Log#	Question	Staff Response(s)
001	What NAICS codes does the pro forma model use to project future demand? Does this model take into account online sales tax revenue vs. brick & mortar or geographical differences (TC vs. South End, etc.)?	<p>The pro forma model used to estimate supportable retail growth was revised following the April 20 City Council presentation. The revised estimate uses only taxable retail sales receipts from NAICS 44-45 (Retail Trade) and NAICS 71-72 (Arts, Entertainment and Recreation and Accommodation and Food Services). This subset of NAICS sectors better represents the types of commercial uses that are the subject of this study.</p> <p>According to the Finance department, the City only receives tax revenue data from DOR based on NAICS codes. The codes convey the business sector and category for tax revenues, but they do not provide the level of detail necessary to distinguish between brick & mortar and online sales. At this time, we cannot determine to what extent the sales from a given category are strictly online or further determine the vendor of those online sales (i.e. cannot distinguish Amazon sales tax revenue vs. on-premise retail sales revenue in

**Figure 2 Uses Required Adjacent to Street Frontages**

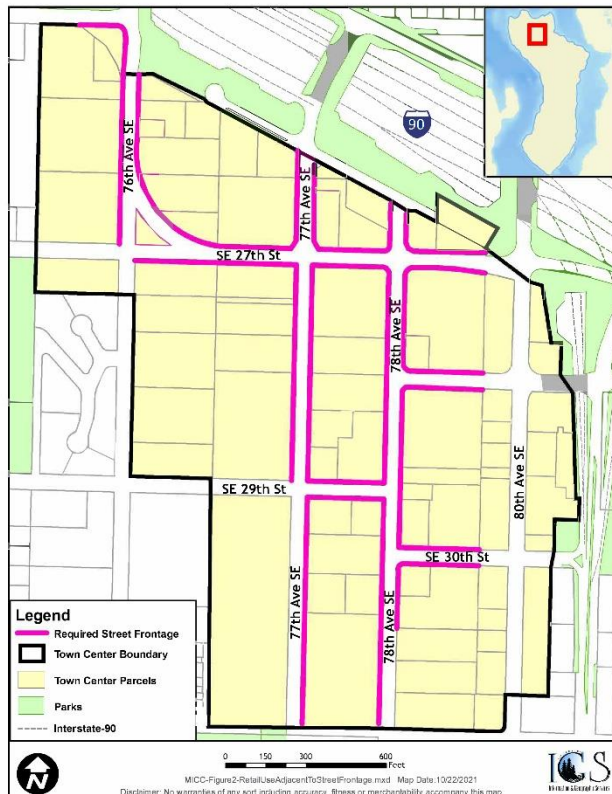
005	Does the comprehensive plan include applicable policies or references that need to be updated?	<p>Staff reviewed the 2015 Comprehensive Plan and did not find specific goals or policies requiring immediate updates. However, MICC 19.11.020(B) Figure 2 is duplicated in the plan and will need to be removed regardless of the outcome of these proposed code amendments. This will be completed as part of the next periodic update to the Comprehensive Plan, scheduled to commence in 2022 and required to be completed by 2024.</p>
006	Did staff consider a variable FAR?	<p>No. For a balanced effect, a consistent commercial FAR is proposed to be applied to the parcels identified for such.</p>
007	Do the pink lines only identify which properties have to have retail or do they also identify on which side of the property the retail has to be located?	<p>Yes, retail space must be provided along the street frontages indicated by the pink lines, per the requirements in MICC 19.11.020(B).</p>
